# CITY OF ALBUQUERQUE

May 9, 2022

**Re: Chase Bank ATM**  
**201 San Pedro Dr SE**  
**Traffic Circulation Layout**  
Architect's Stamp 05-04-2022 (K18D091A)

# A00

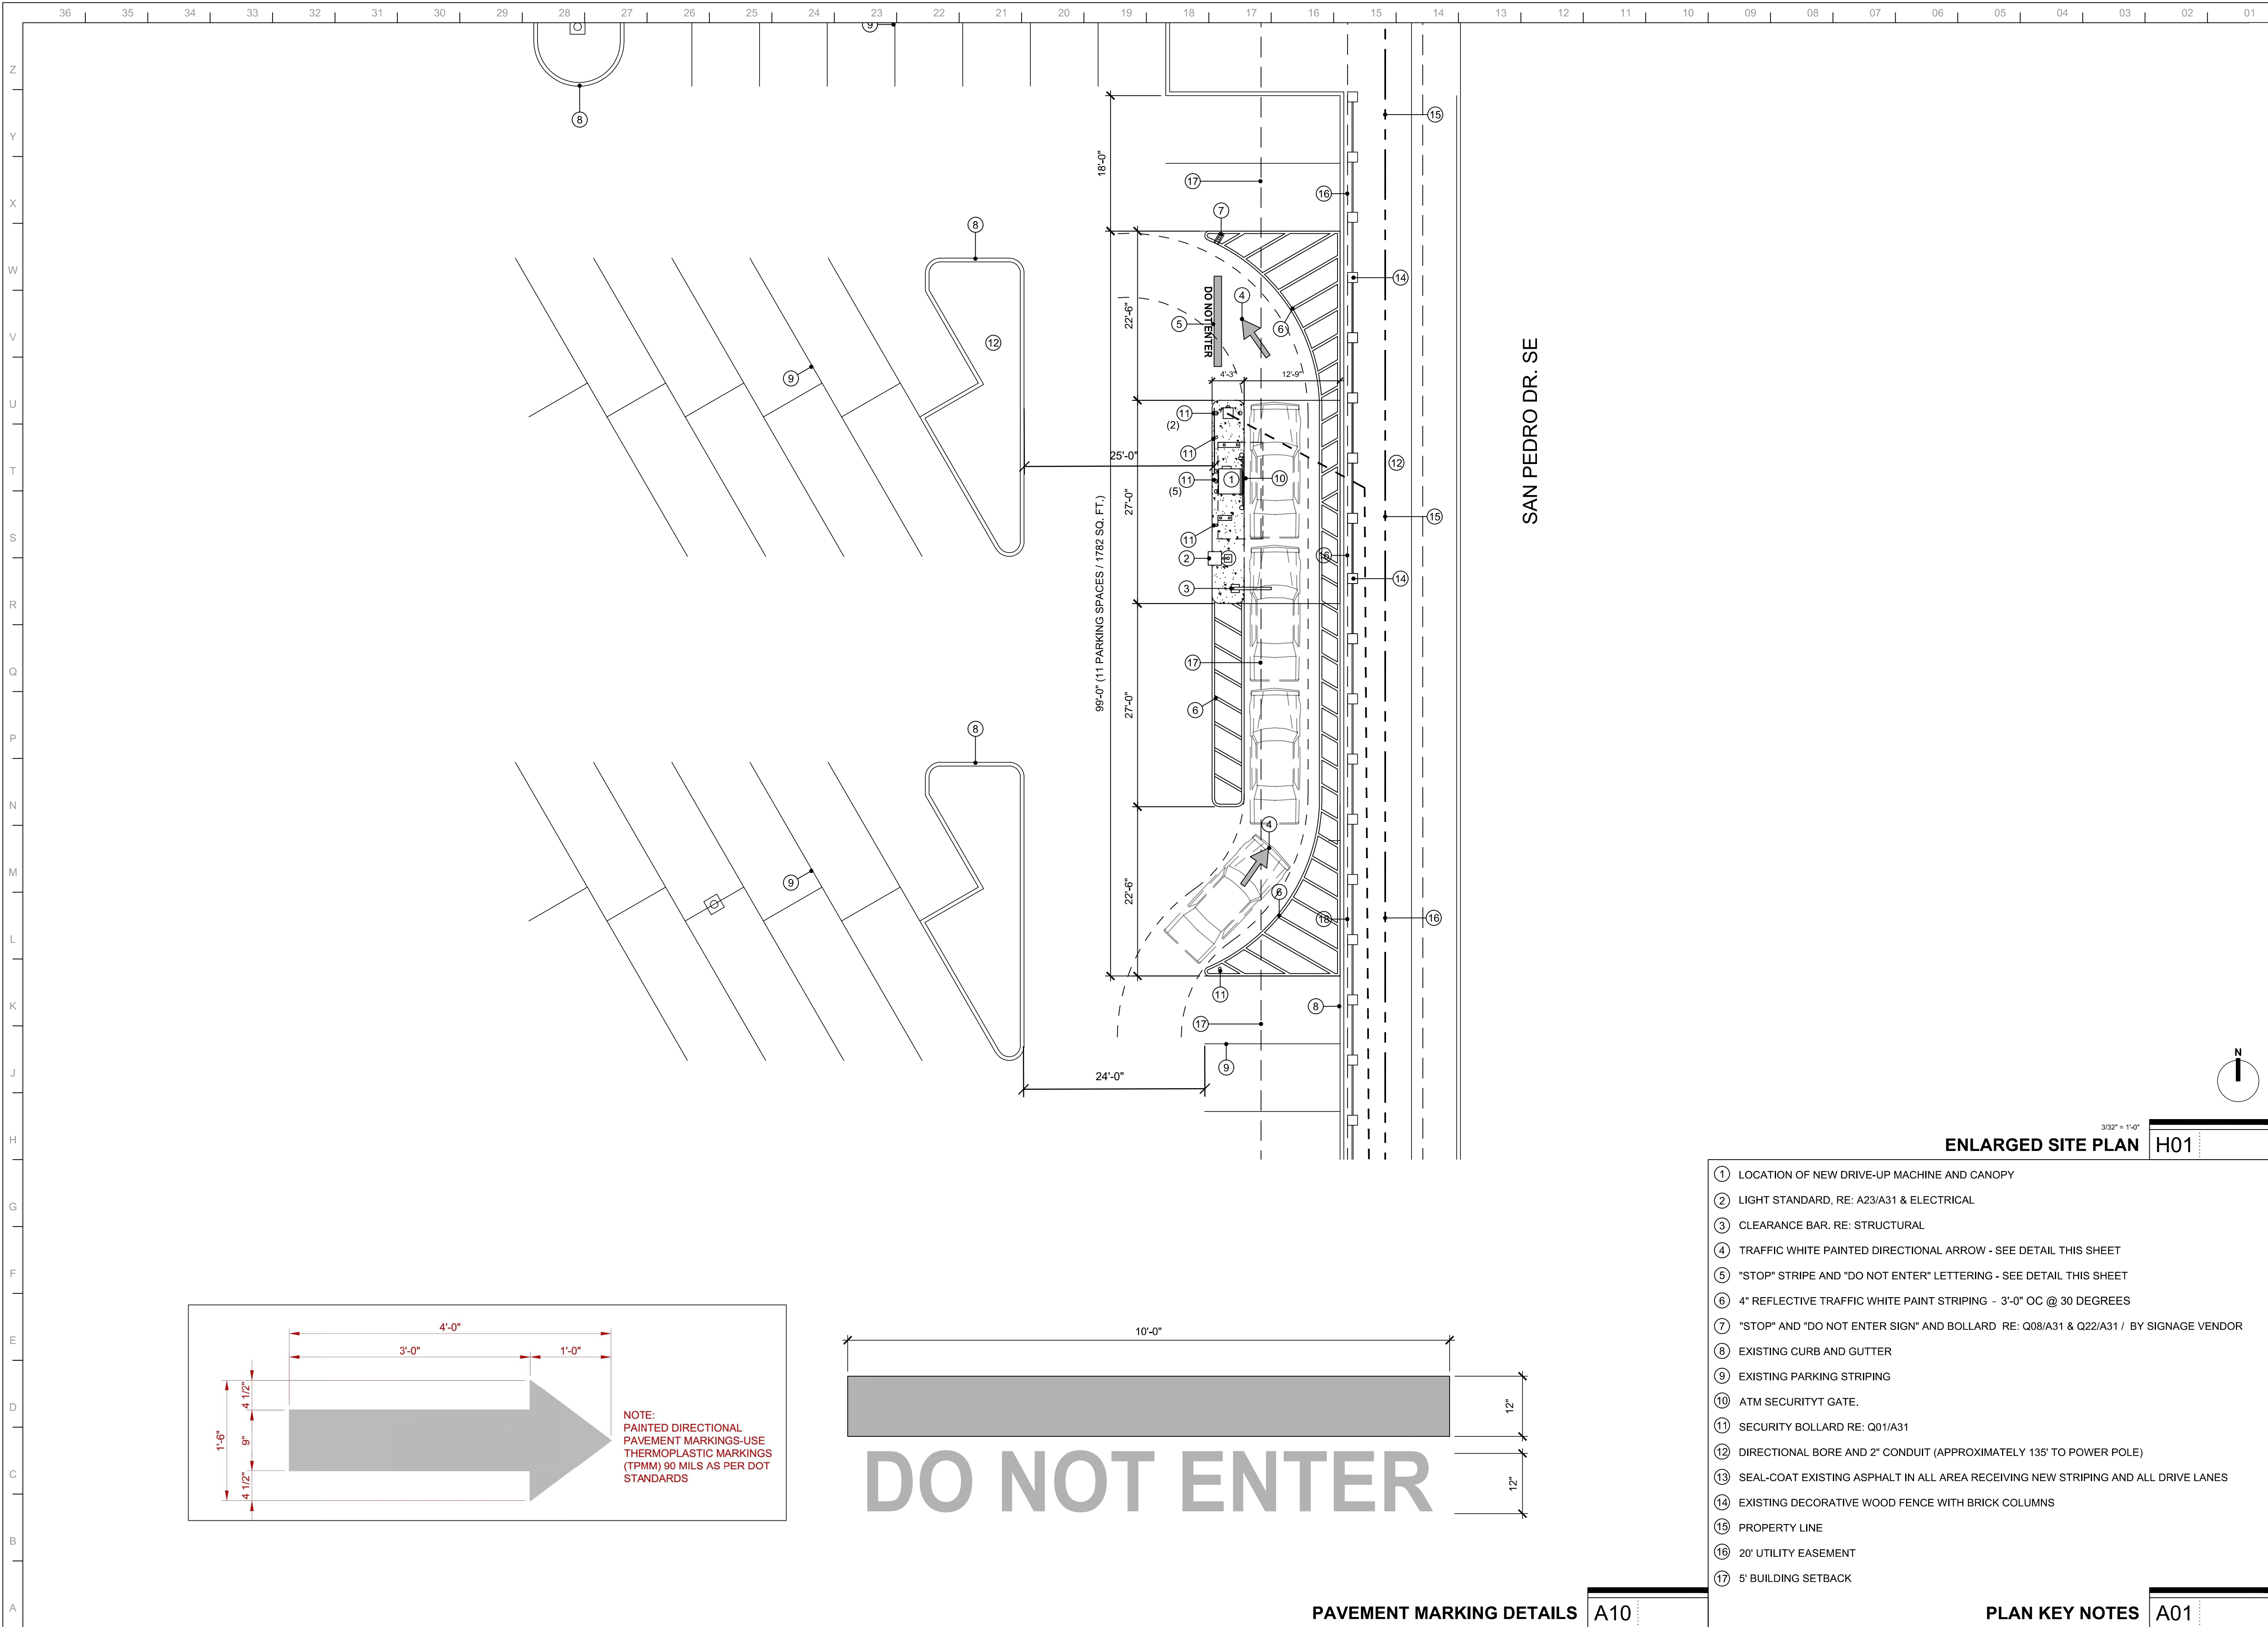
1. Please show a vicinity map showing the location of the development in relation to streets and well known landmarks.
2. The traffic circulation layout must be stamped, signed, and dated by an engineer or **architect licensed in the state of New Mexico.**

**A11**

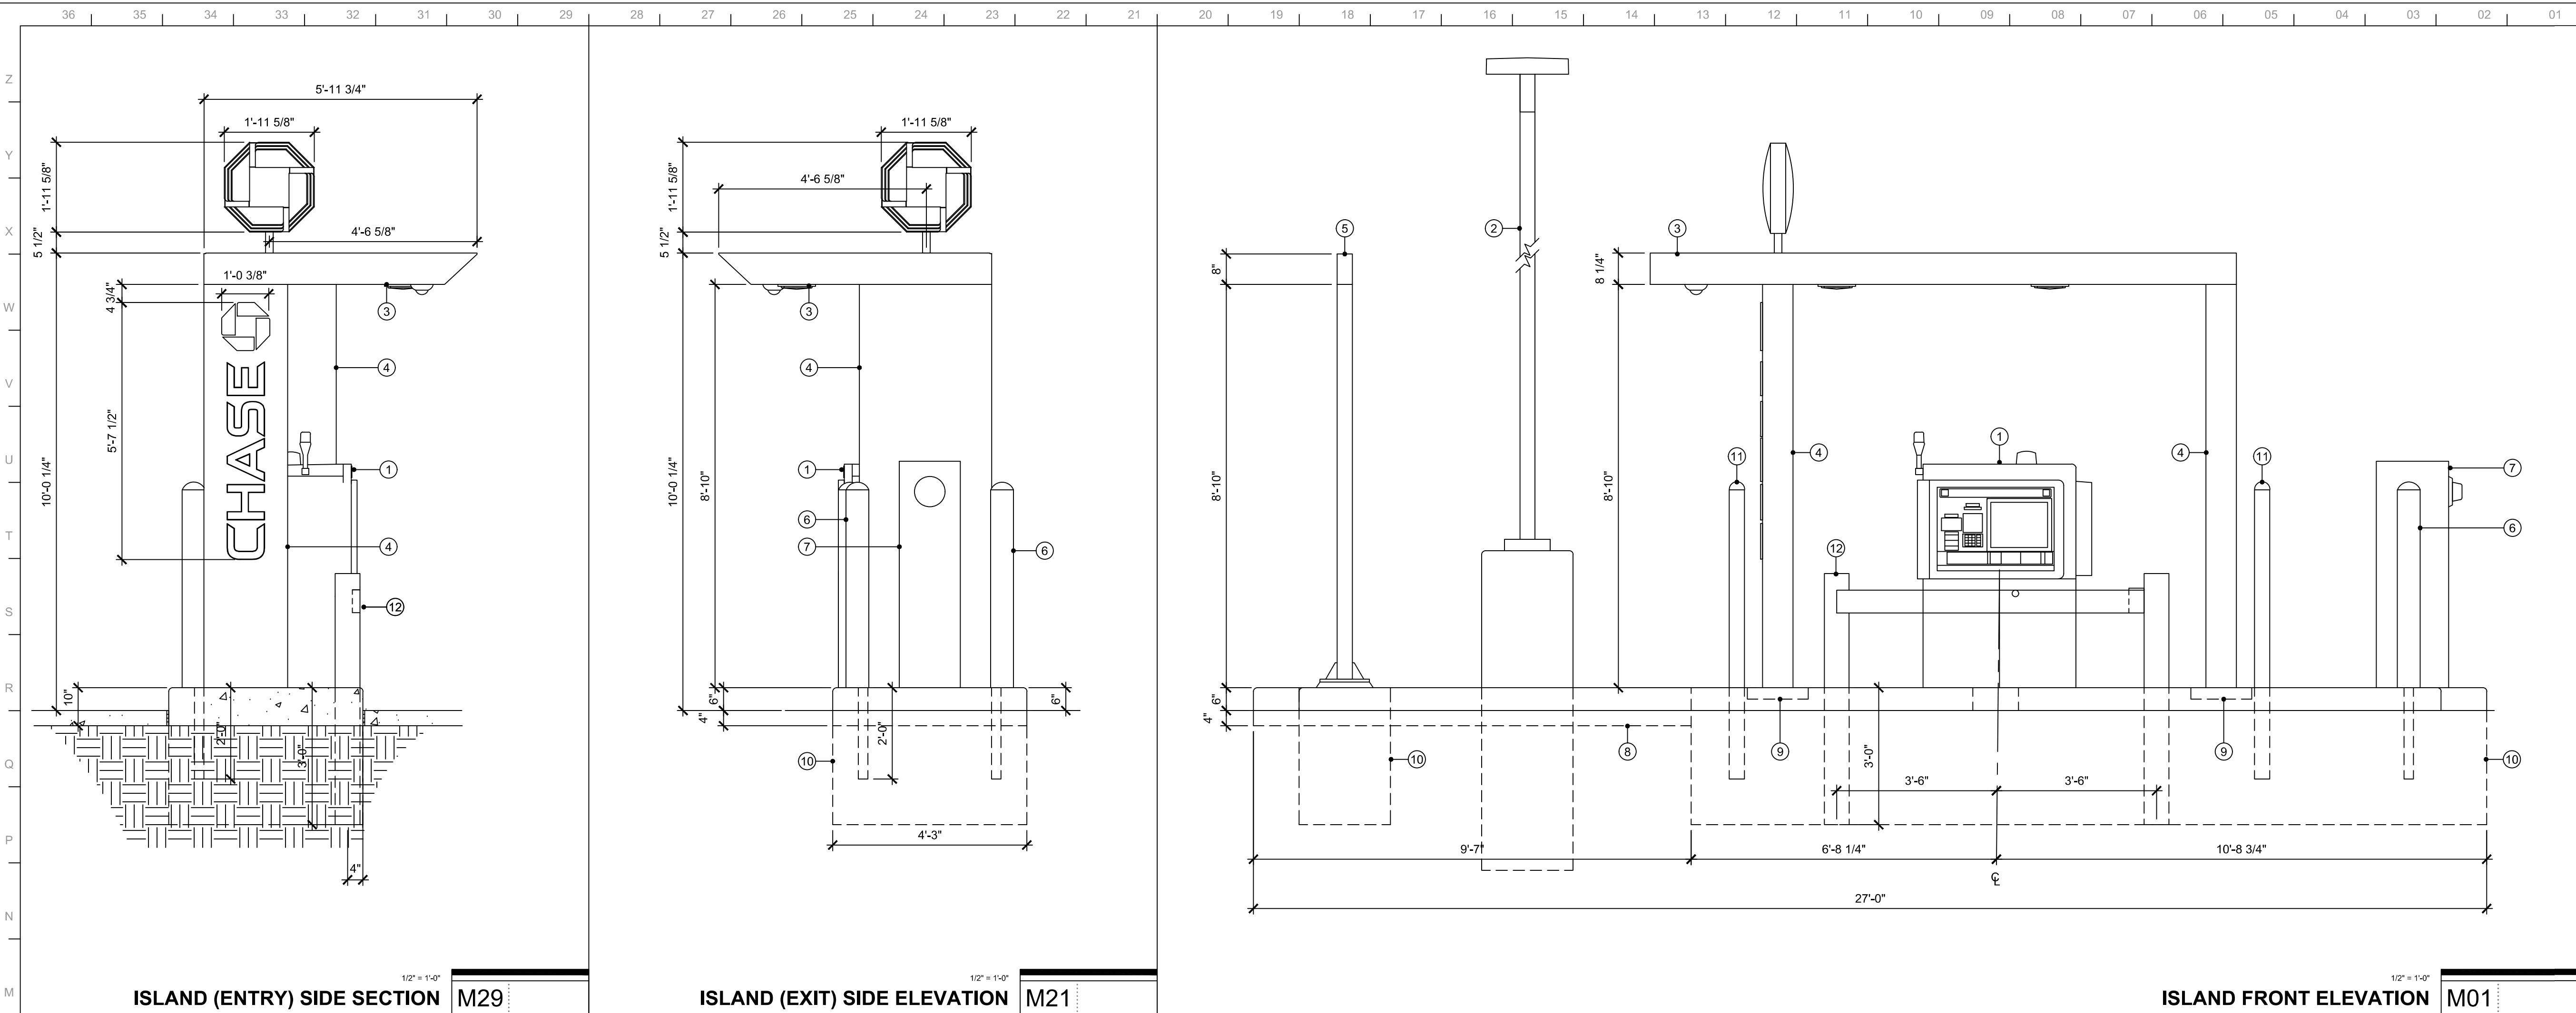
3. **Keyed Note 4:** Provide details (include size and color)
4. **Keyed Note 5:** Detail will be needed (include stop bar size and color for text and stop bar)

5. **Keyed Note 6:** Angle, color and size will need to be provided.
6. **Keyed Note &:**
  - Provide Stop sign and sign face details.
  - DO NOT ENTER sign and sign face detail will need to be provided on both sides of exit.

7. Provide the drive aisle width adjacent to the proposed ATM infrastructure.
8. Provide the offset between ATM exit drive thru lane and the opposing parking stall. You will need at least 10 ft offset between them.
